**Development Application and Planning Proposal Review
NSW Planning Portal Concurrence and Referral**

Authority	Authority's Reference	Agency Concurrence and Referral	Authority Contact	Authority Notification	Submission Due	Submission Made
NSW Dept. of Planning & Environment	SSD-41306367		Teresa Gizzi	8/11/2022	7/12/2022	10/11/2022

Address	Land Title
Gregory Hills Drive, Gregory Hills	Lot 3257 DP 1243285

Environmental Impact Statement (EIS) for the New Primary School at Gregory Hills. Construction of a new primary school comprising one and three storey buildings, outdoor play spaces, parking and associated works.

DRAWING NO.
DA.04

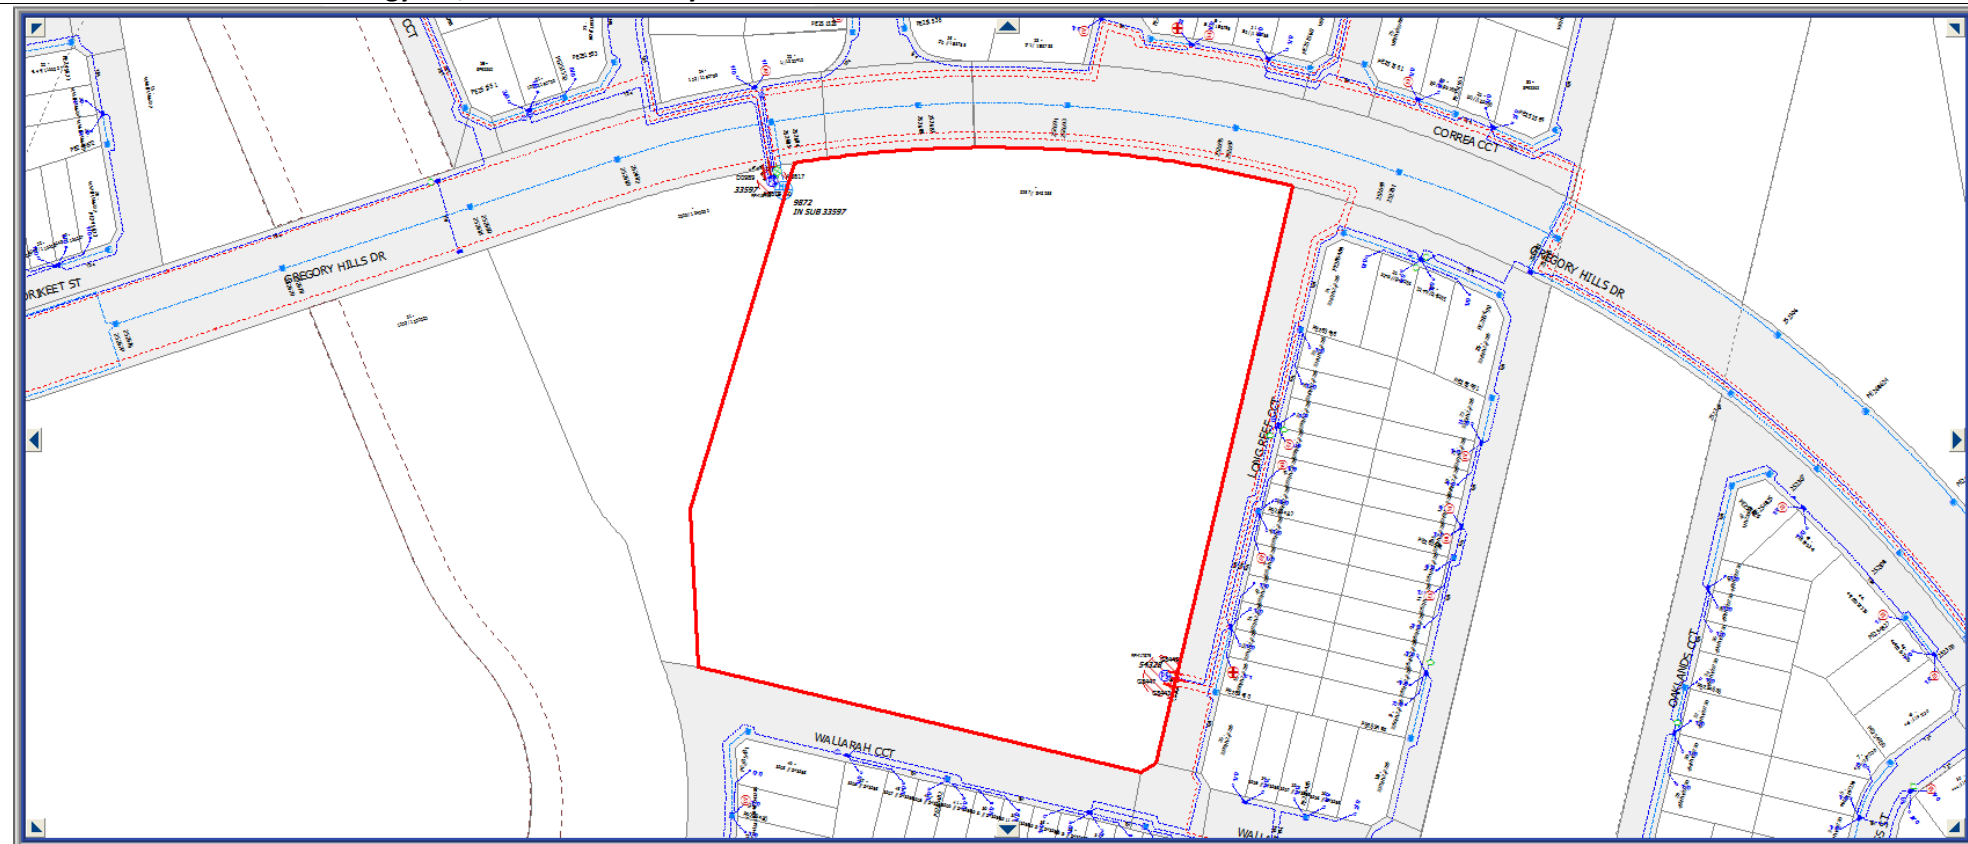
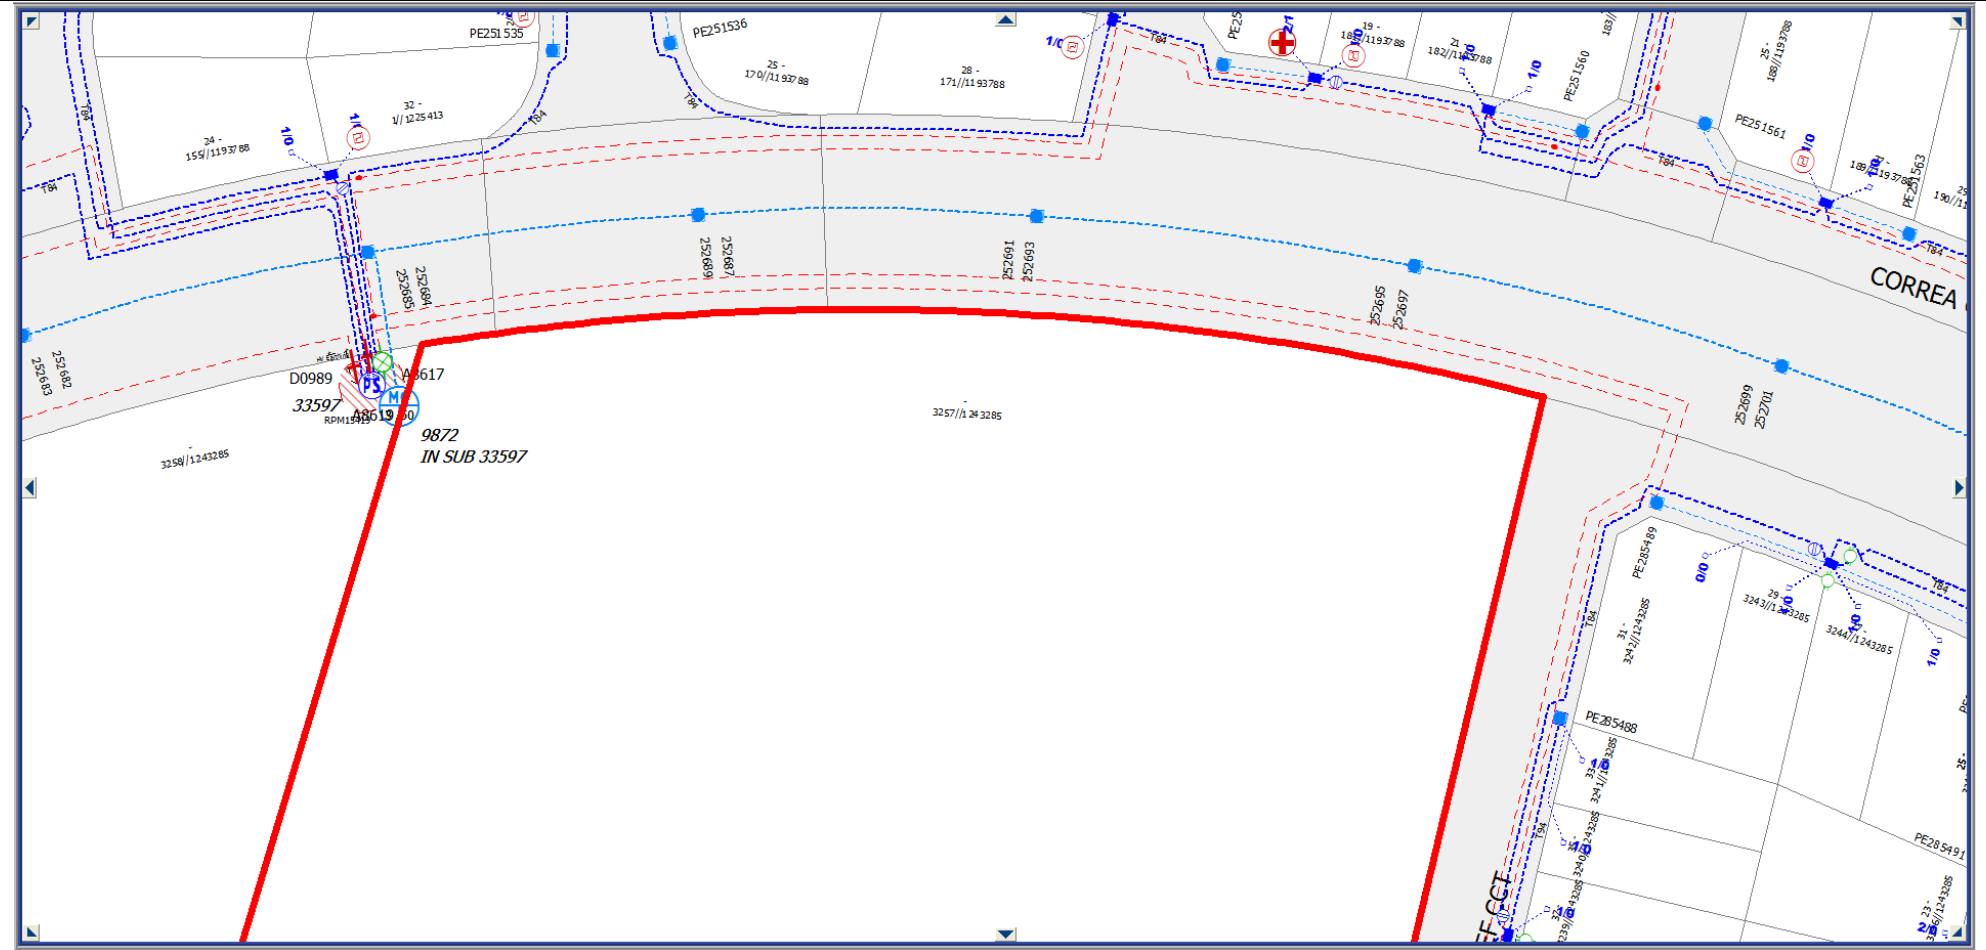
The Site Plan shows the padmount substation cubicle / plinth and possibly the easement but it does not show the restrictions. These are however shown in the above Figure E1 Electrical Infrastructure Site Plan but should be included in all the plans. There are no buildings or structures encroaching the easement or the restriction for fire rating and there is no swimming pool or spa proposed.
